TREVOR E. UNSTED LTD

**Re: 2 Bedroom Bungalow on Land to East of Pumping Station,
Highcroft Close, Bognor Regis, West Sussex, PO22 8DS**

Your Ref: BR/80/17/PL

PROPOSED GROUND FLOOR PLAN
& SITE BLOCK PLAN.

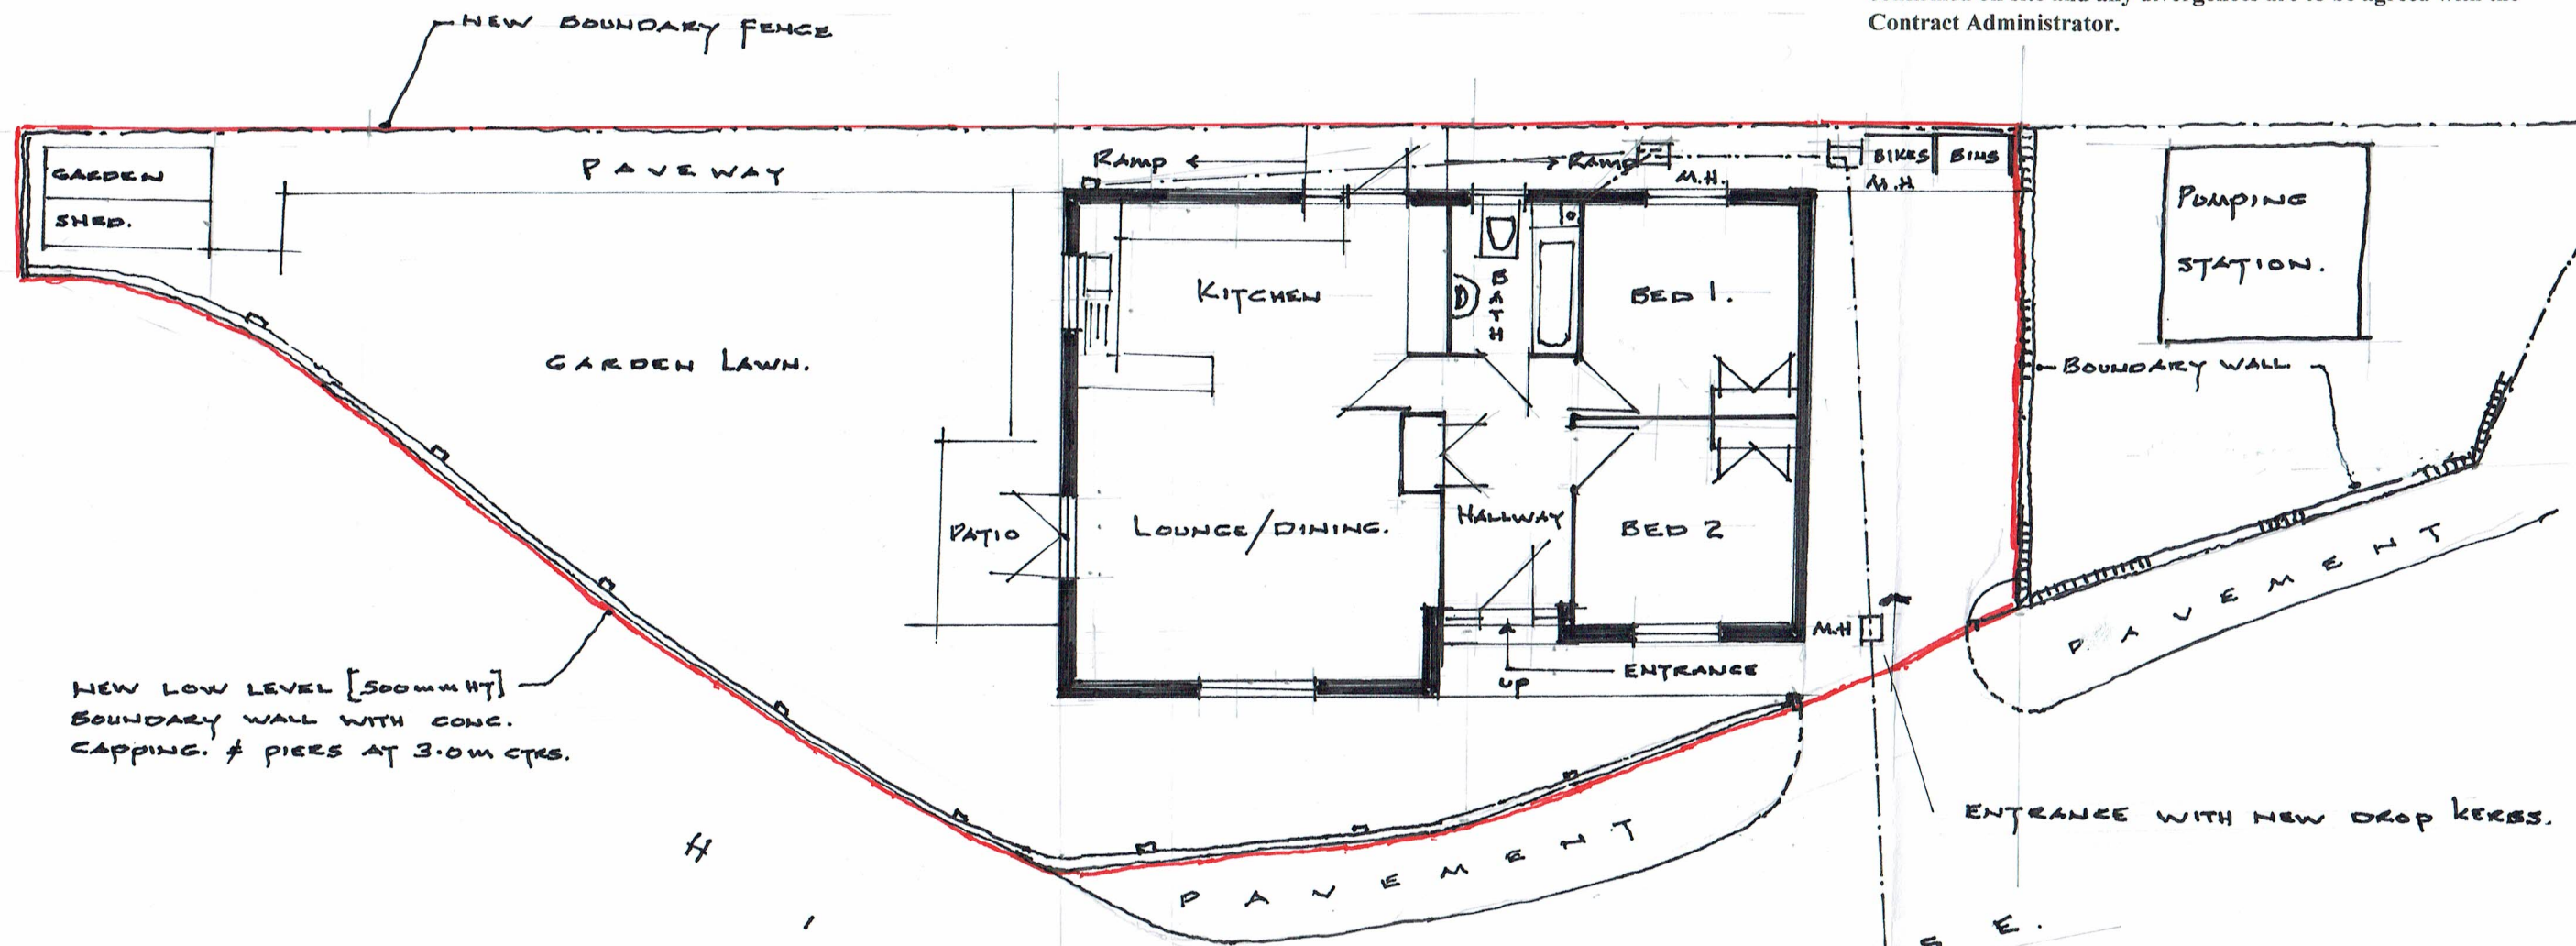
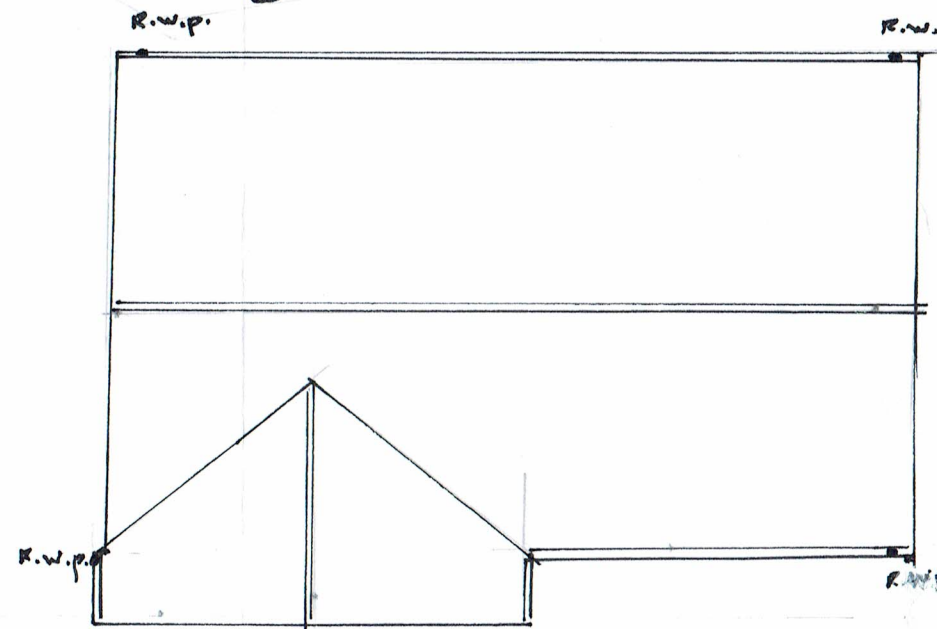
3. The front boundary (north) is enclosed by a 500mm high wall. Whereas this is quite acceptable in front of the dwelling and certainly in accordance with existing front boundary treatment within the Close, I would suggest that the area to the east between the proposed dwelling and the boundary of N° 6, should be properly enclosed to provide reasonable privacy and containment for the benefit of the existing residents and the future occupants of the proposed dwelling. It is further suggested that a brick wall, say 1800-2000 high would be a suitable treatment in this location.

5. Having studied the application, I note that there are inaccuracies or omissions which should be addressed, albeit post validation.
- i. The site slopes down from north to south and this has not been indicated.
 - ii. Dimensions from the bungalow to the boundaries are not shown, in fact, no dimensions have been shown.
 - iii. No section and/or vertical heights are shown.
 - iv. Scale bars would have been helpful.
 - v. On drawing 5070/2 the roof pitches vary between 36° and 42° according to which elevation or roof slope is measured.
